From: Simon Davis
Sent: 14 October 2019 12:03
To: Rebecca Redford [REDACTED]
Subject: RE: Yapton Metal Company - refs Y/42/19/DOC and Y/61/19/PL

I would like to request a further change to the layout/landscaping plan please. The hedge is great but I see that there will be a section of fence on the northern boundary which will face Burndell Road. We would like this to be hedged also.

Site Plan (Proposed) 1:200

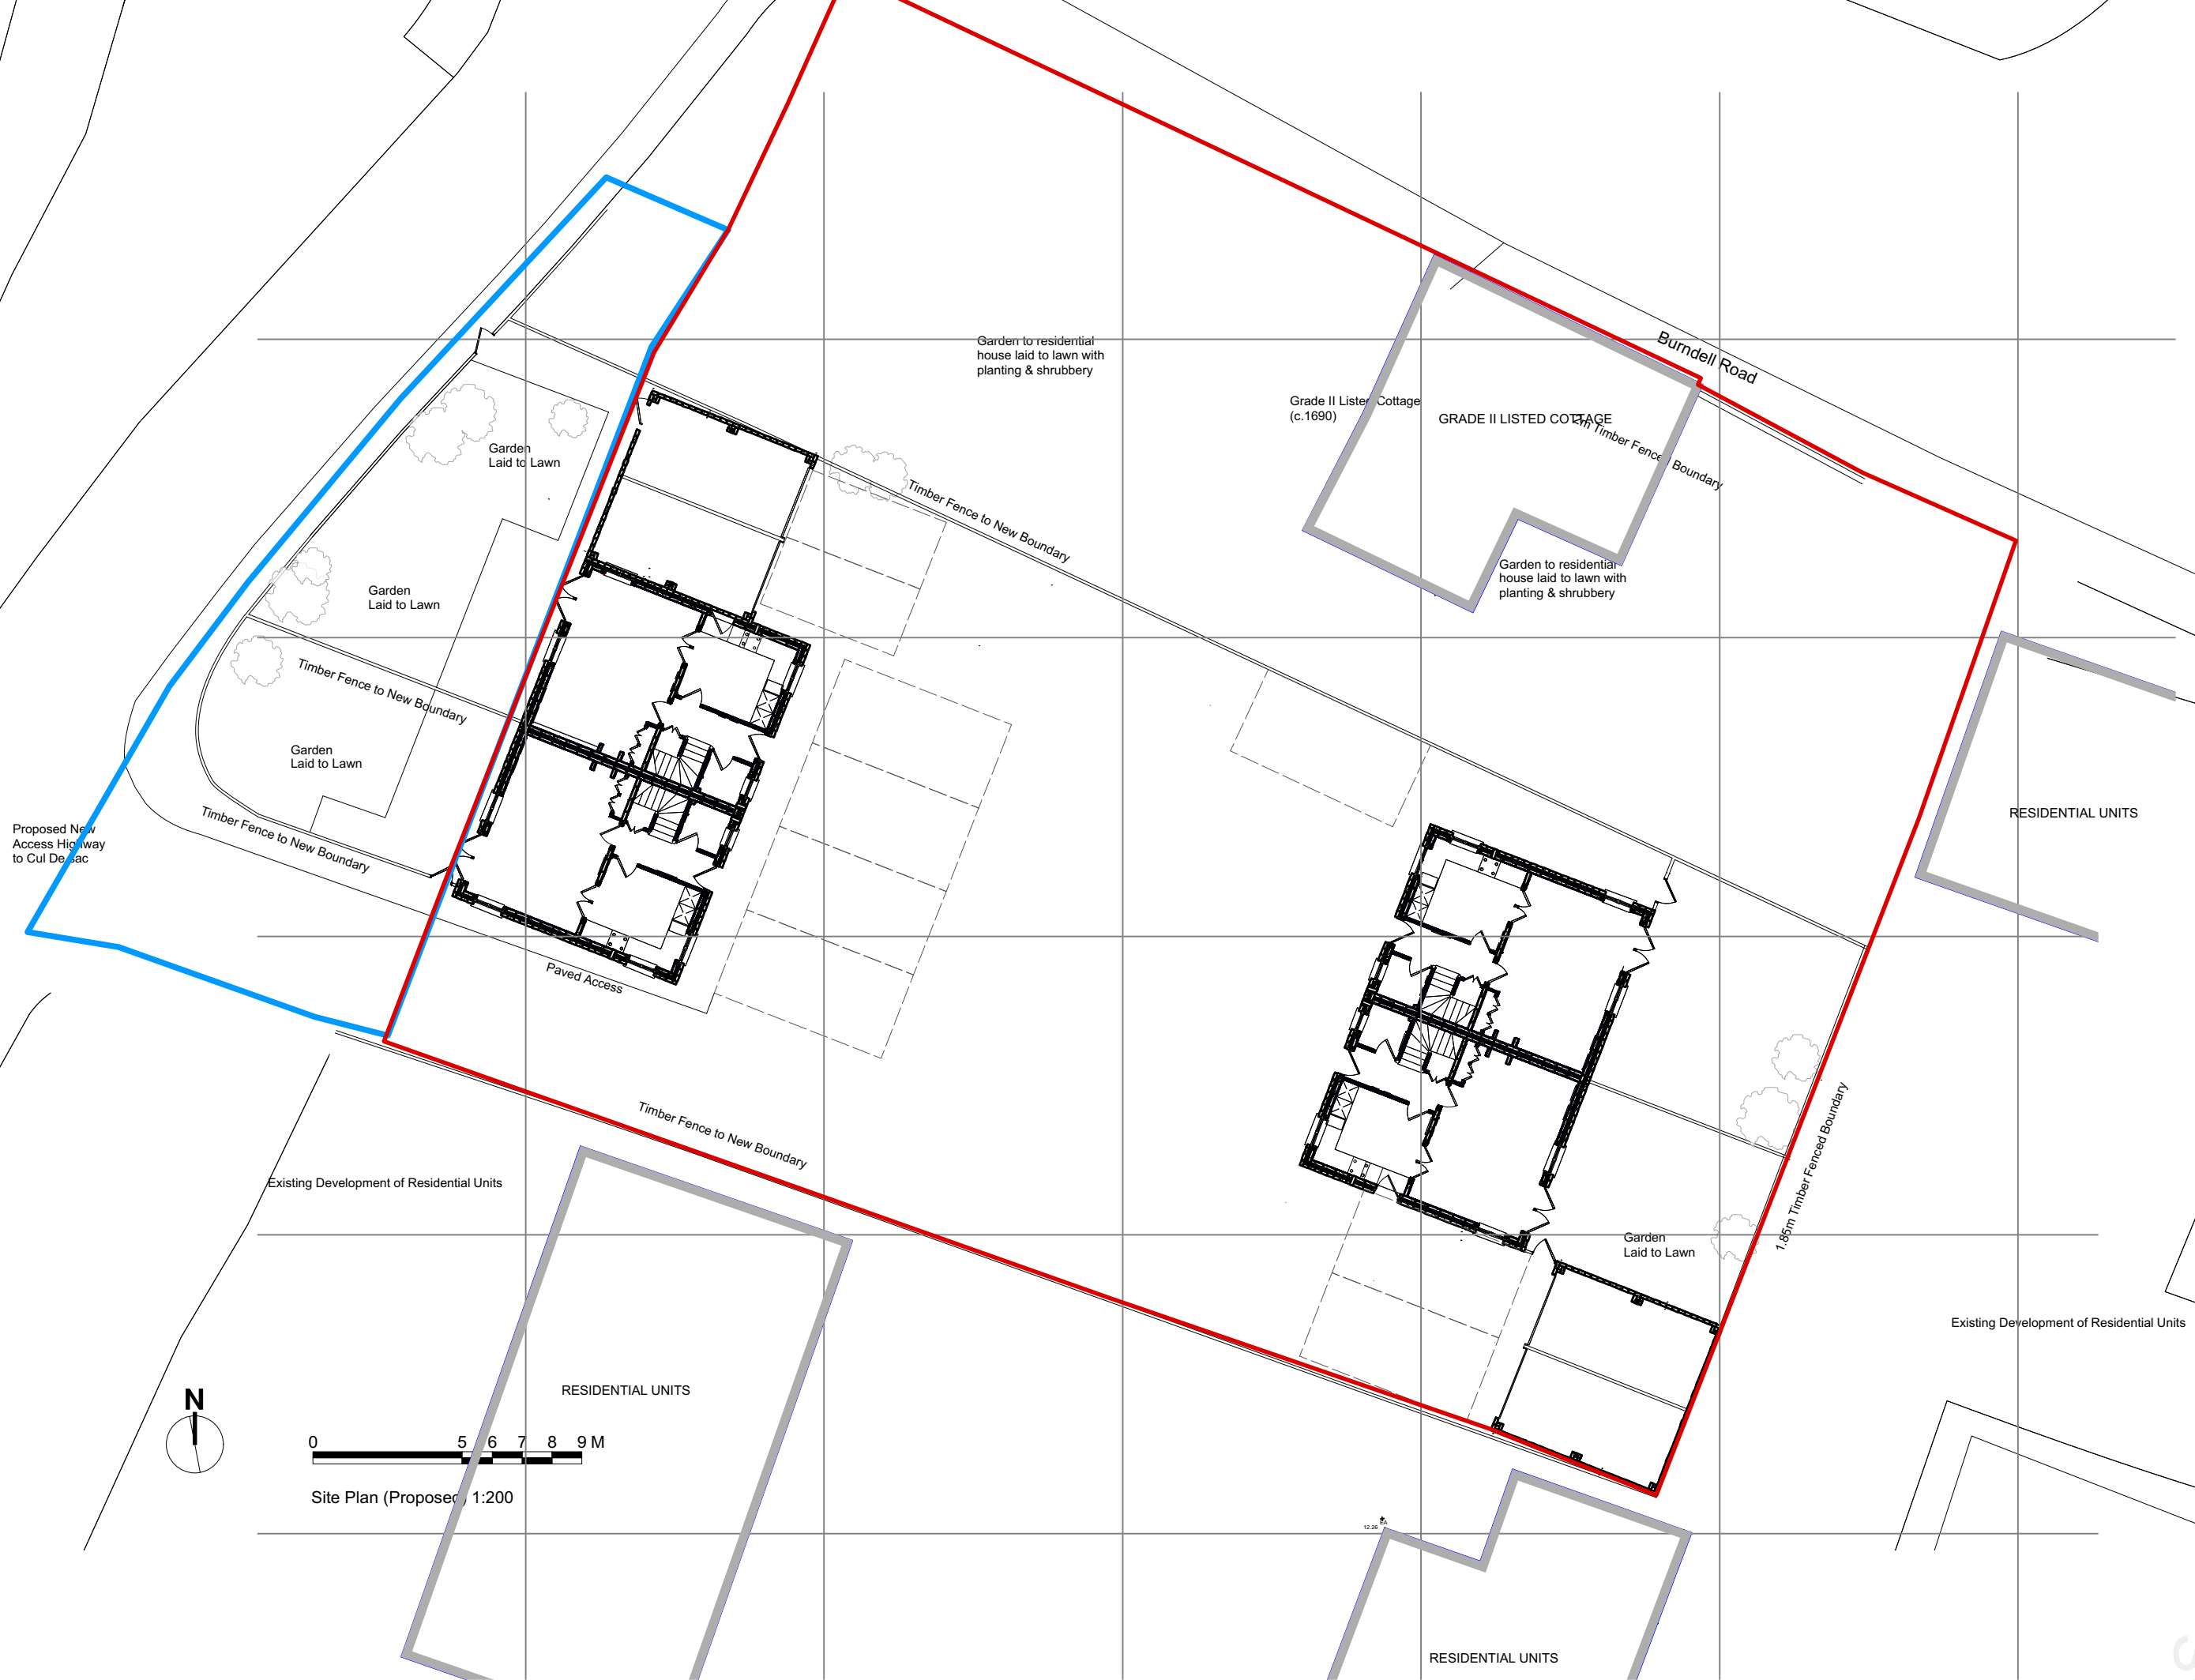
On this basis, please amend the plans to show hedge in place of the section of fence.

In terms of the fence in question, the site manager has also informed me that it has recently been put up by the Bovis' site crew as part of their landscaping strategy for the entrance to their site. I believe the piece of land to the north of the fence has been incorporated into Bovis' landscape scheme although strictly in the ownership of the applicant. I have had a quick look at the approved landscape plans for the Bovis site and it would appear to be that in front of the fence will be a shrubbed area with a tree in it, screening the fence. If this is not how you understand the scheme please let me know and I am sure the applicant will have no issue with replacing the fence in out scheme with a hedge.
